T-BONE CONSTRUCTION, INC.  
1230 AINSWORTH ST  
CODE 200 AT PRESENT NORTH

SOLACE AT CIMARRON HILLS  
- FILING NO. 1  
SITE AND OVERALL UTILITY PLAN  
SHEET 4 OF 32  
JOB NO. 25174.00

SOLACE APARTMENTS - FILING NO. 1		SHEET 5 OF 28
SITE AND OVERALL UTILITY PLAN		
JOB NO.	25174.00

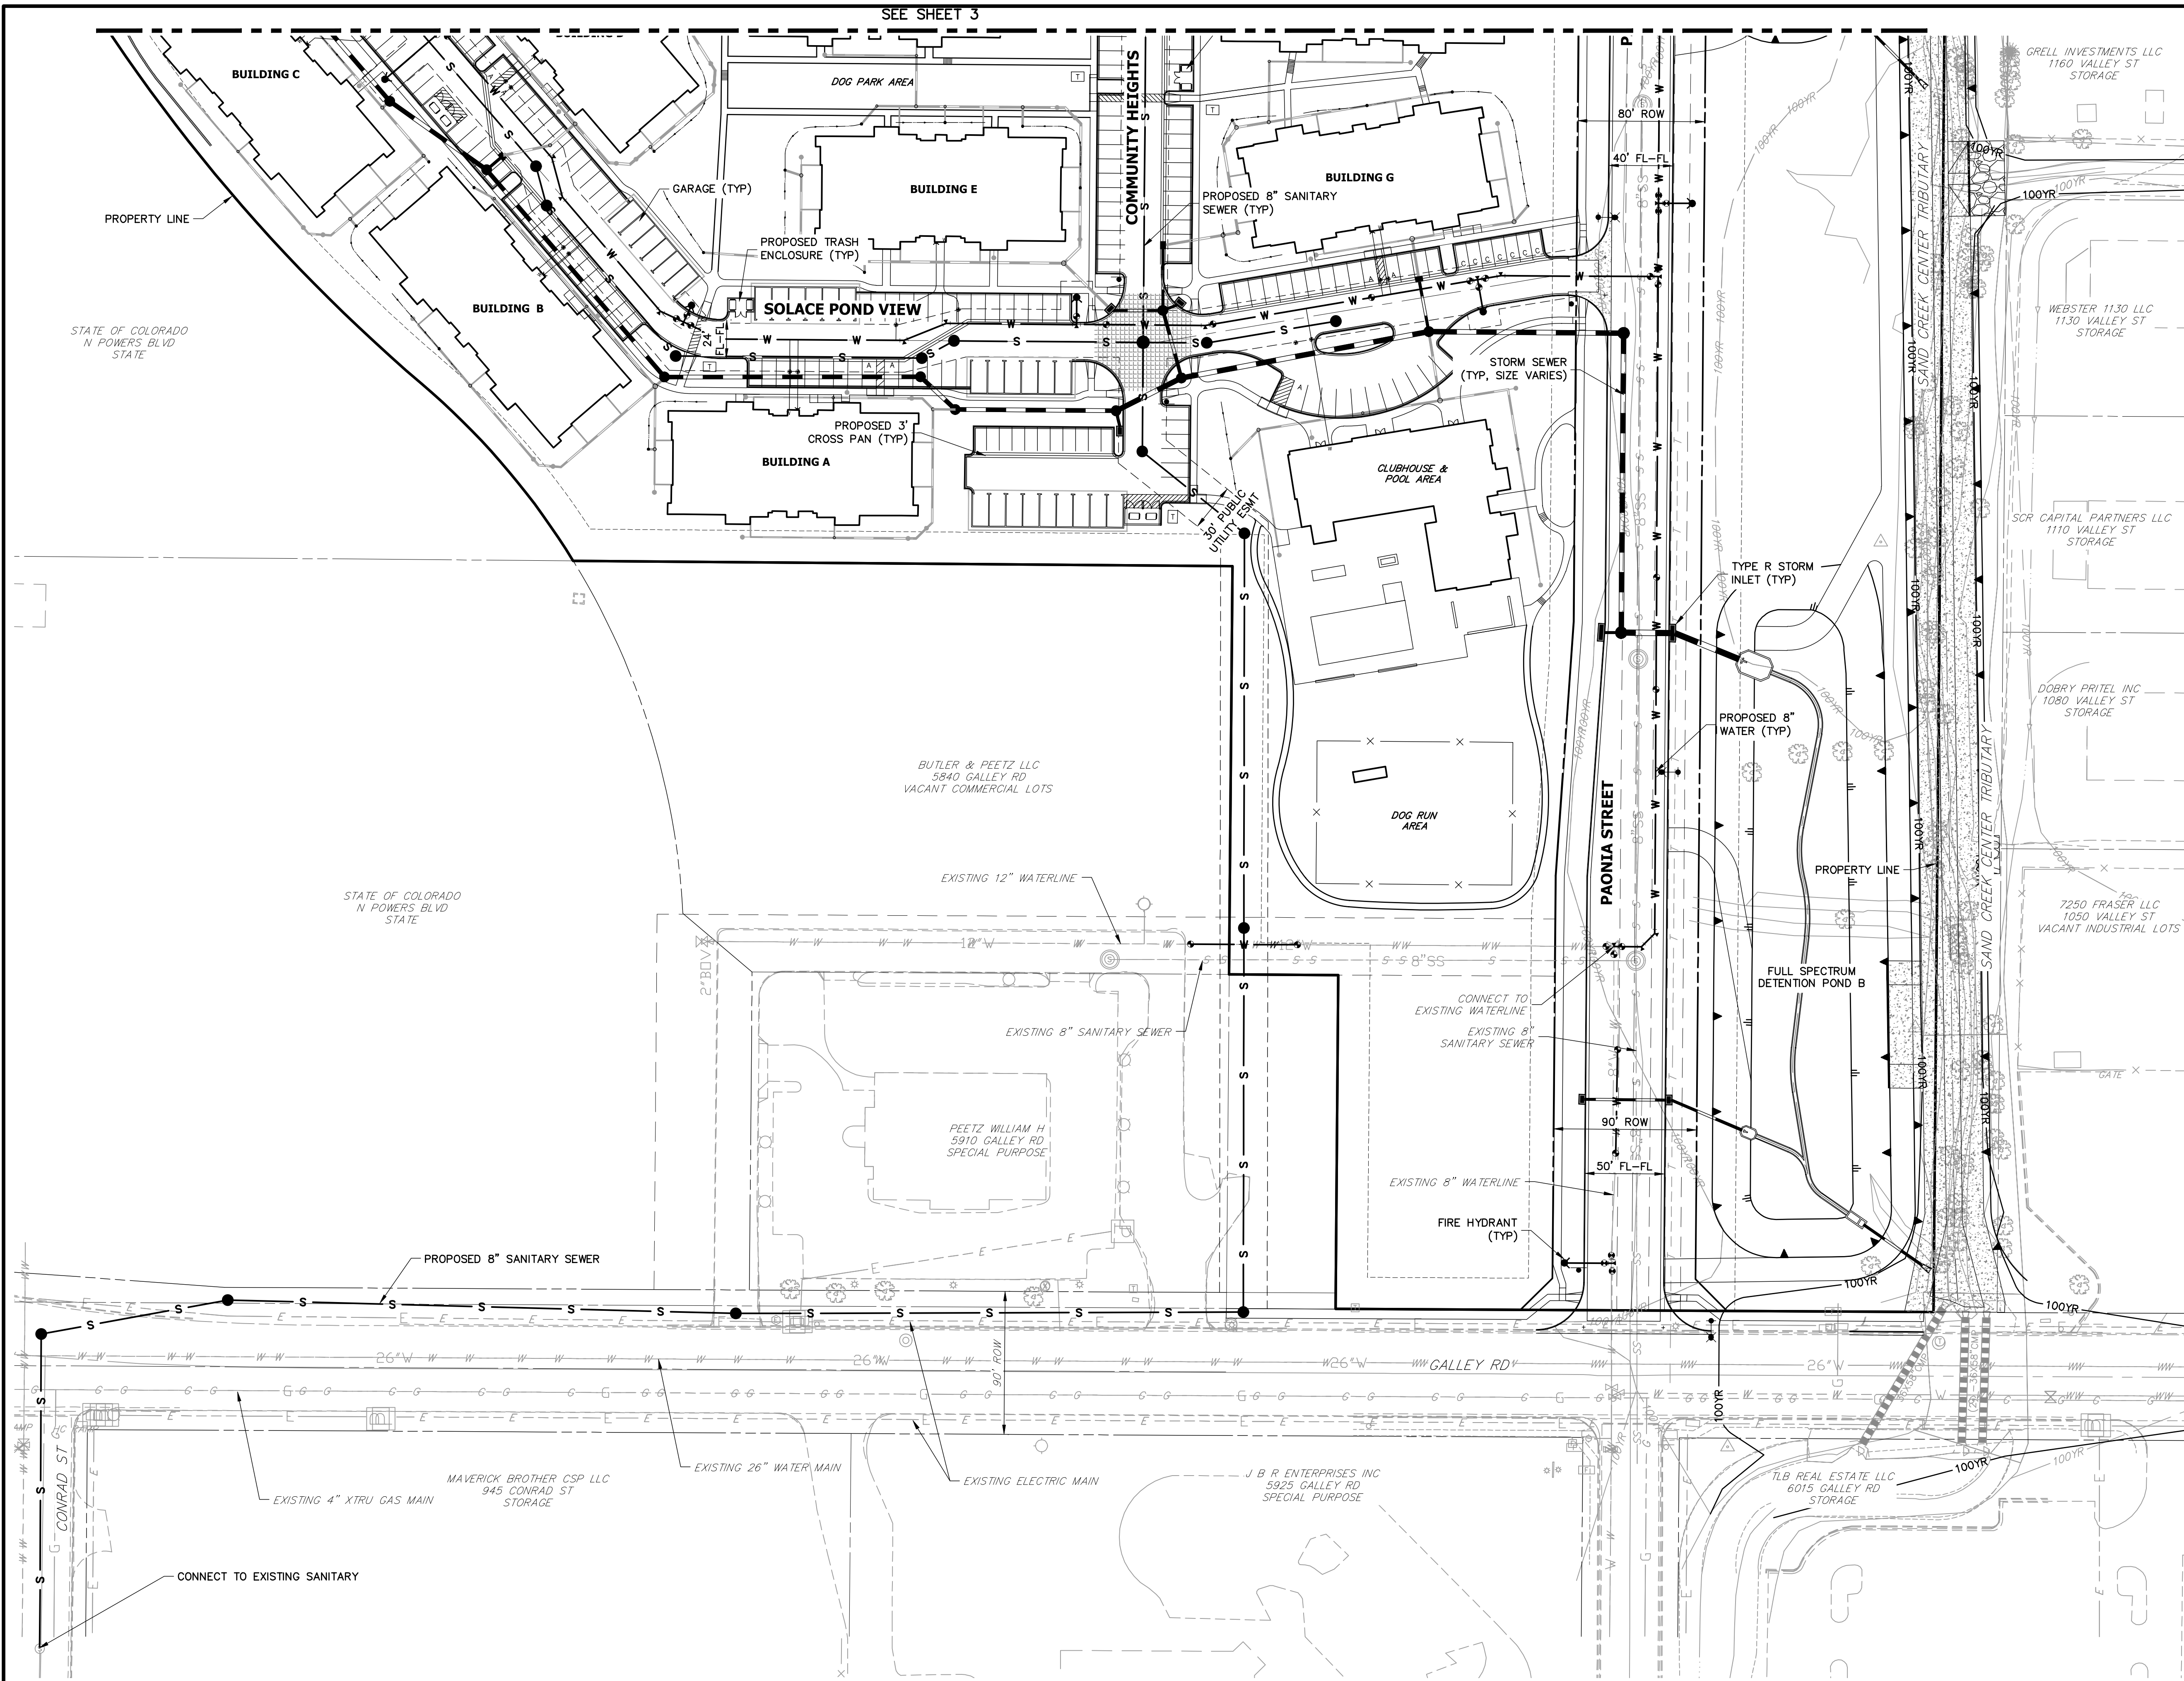
3 Label Service & FIRE LINES & PROVIDE PIPE SIZE & MATERIAL

1 SHOW SANITARY SEWER CONNECTION TO BLDG.

2 IF PUBLIC SANITARY WATER & SEWER SYSTEMS SUBMIT PIPE PROFILES W/ CROSSING DETAILS

4 IF PUBLIC WATER SYSTEM ADD NOTE THAT CHEROKEE RESPONSIBILITY ENDS AT MAIN TRAP VALVE - SERVICE TO BLDG IS OWNER'S RESPONSIBILITY

5 ADD VALVES TO ISOLATE BUILDINGS

6 IF PUBLIC WATER & SANITARY SYSTEMS- ADD NOTE THAT OWNER RESPONSIBLE FOR PAVEMENT REPLACEMENT IF REPAIRS ARE NEEDED

Typical fire and water service lines labels added. Please also see water specific construction plans submitted with this package twice.

Noted. Please also see sanitary specific construction plans submitted with this package twice.

Public. Please also see sanitary specific construction plans submitted with this package. These include all profiles and crossing details.

NOTE 1 ADDED TO BOTTOM OF THE PAGE REFLECTING PUBLIC/ PRIVATE TRANSITION

NOTE 2 ADDED TO BOTTOM OF THE PAGE REFLECTING PAVEMENT MAINTENANCE RESPONSIBILITIES.

FIVE VALVES ADDED FOR INDIVIDUAL BUILDING SERVICE ISOLATION.

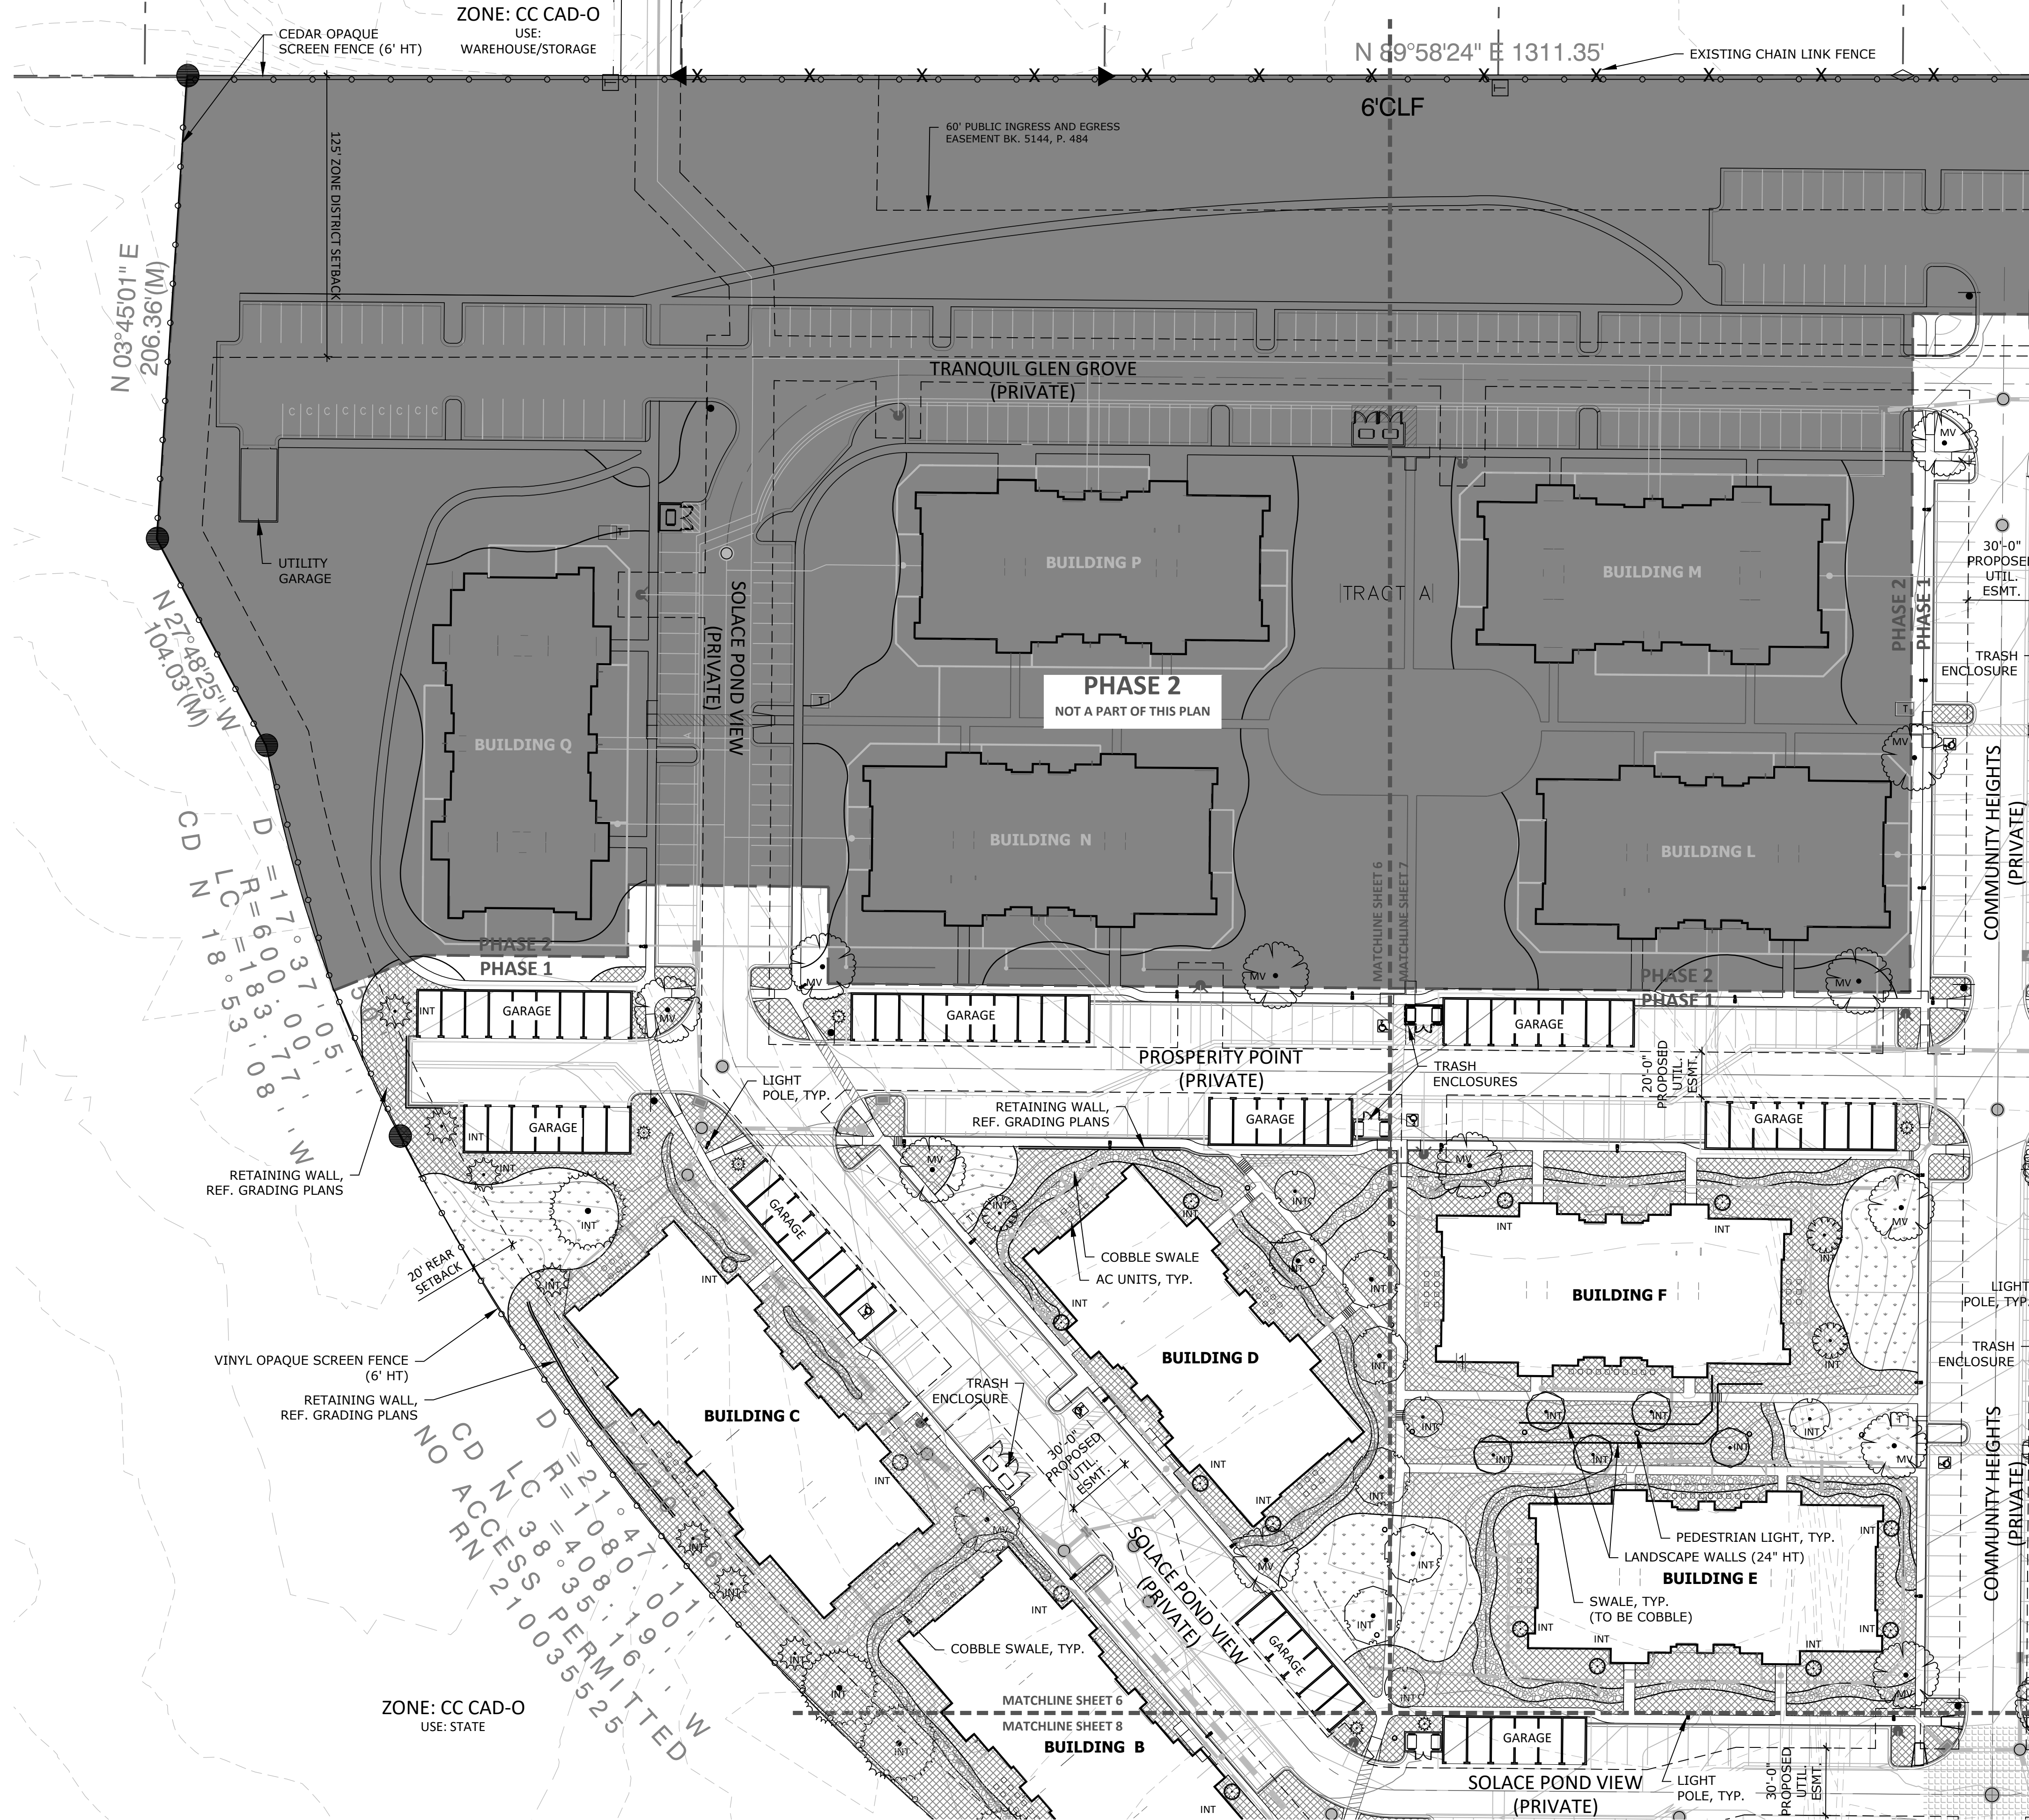
10' EASEMENT TOO NARROW CONTINUE THE 30' EASEMENT NO LANDSCAPING IN EASEMENT

3 - 8" VALVES

No WATER LINE EXISTS NORTH OF GALLEY. EXTEND WATER LINE TO VALVE ON SOUTH SIDE OF GALLEY

CONNECT TO EXIST VALVE

This 30' easement extends south. Additional label added for clarification. The 10' easement shown also runs along the entire western border.

Noted.

this is a 90 degree bend. Added one Valve to the valve already proposed on south side for isolation.

connect to existing updated.

updated. Please see water specific plans submitted with this package as well.
